PROJECT #: 21-2817-A (LOT 161)
LOT 161, DUNCANS CREEK
JANUARY 8, 2025
PAGE: 1 OF 1
RE: STUD COLUMN CLARIFICATION

FIRST FLOOR PLAN 'FARMHOUSE'
 SCALE: 1/8"=1'-0" ON 11x17, 1/4"=1'-0" ON 22x34

The Selma - RH
 NEW HOME, INC.

FIRST FLOOR PLAN 'FARMHOUSE'
SCALE: 1/8"=1'-0" ON 11x17, 1/4"=1'-0" ON 22x34

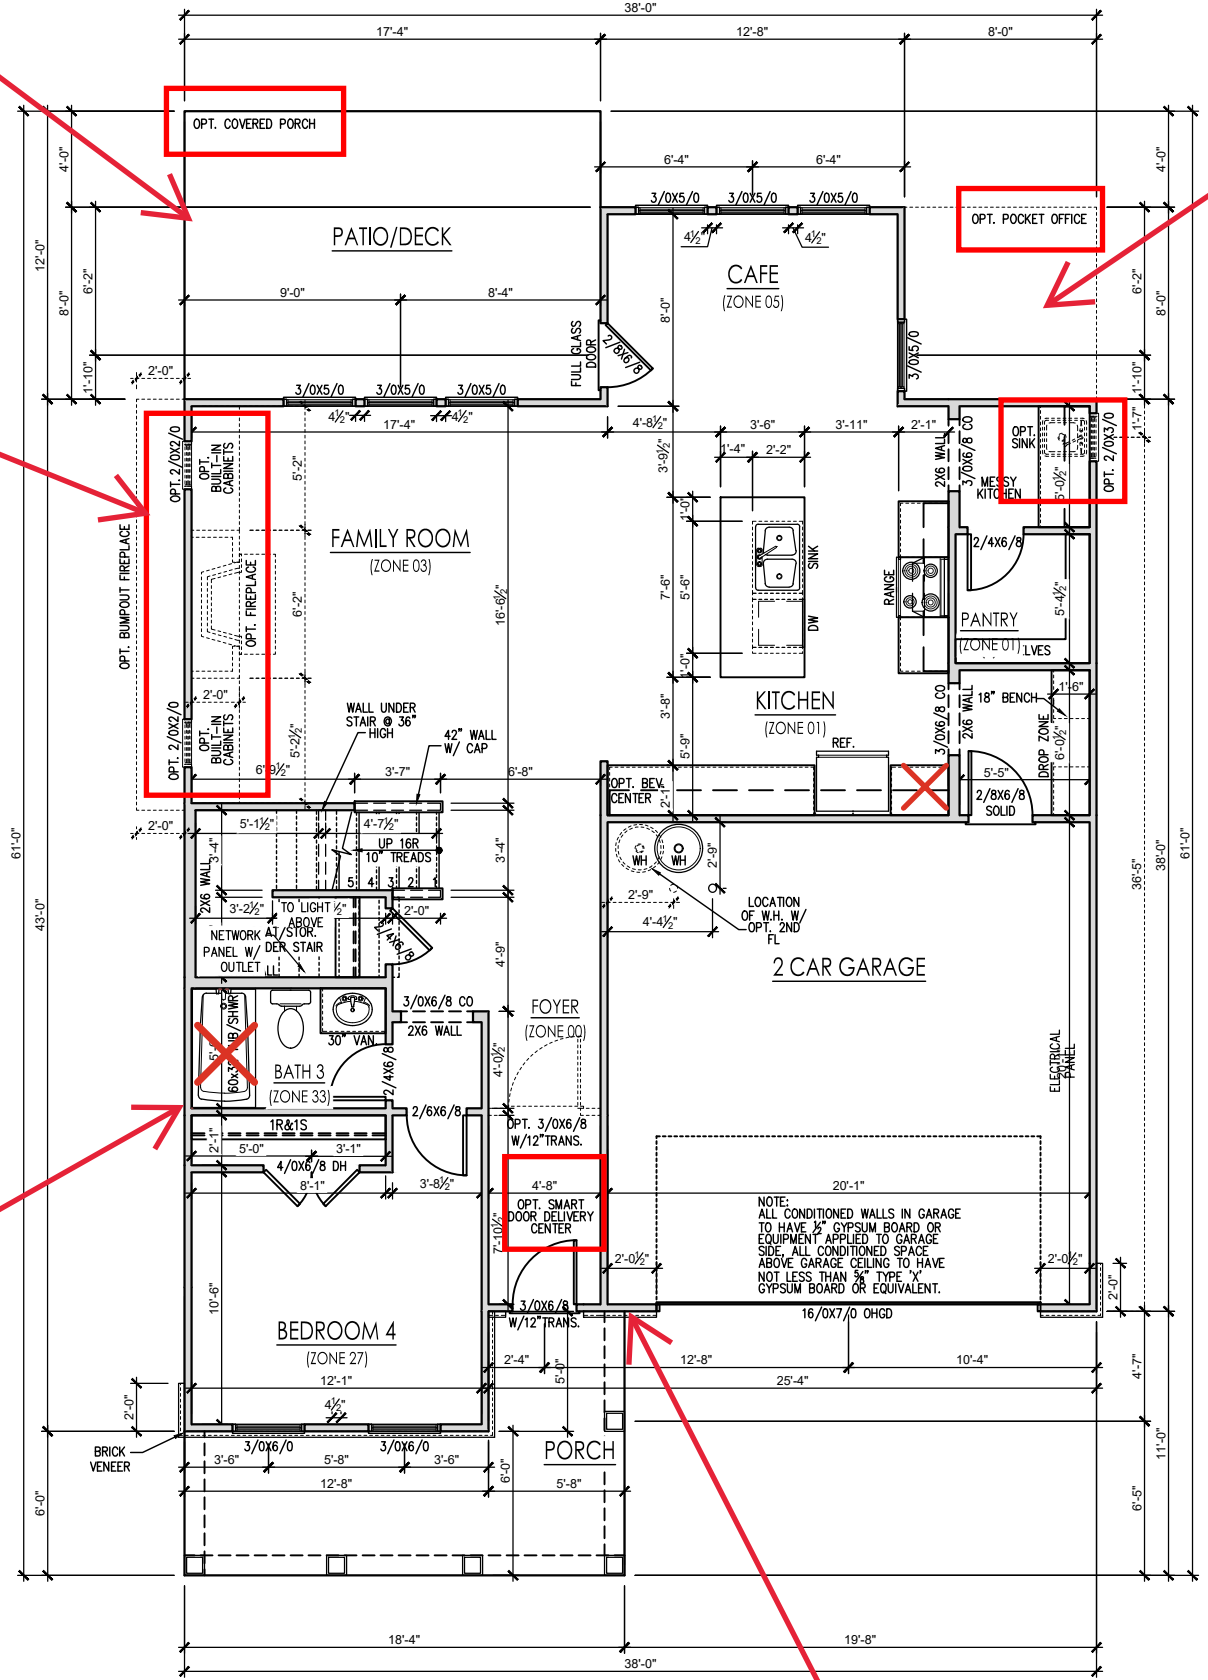
THE FRONT 2 PLIES OF THE BEAM EXTEND 8" ALONG THE WALL. (5) FULL HEIGHT STUDS ARE LOCATED FROM THE CORNER TO THE DOOR. (3) ADDITIONAL STUDS ARE ON THE FAMILY ROOM SIDE OF THE CORNER FOR A TOTAL OF (8) STUDS. THIS EXCEEDS THE MINIMUM NUMBER OF (6) STUDS THAT WERE ORIGINALLY SPECIFIED.
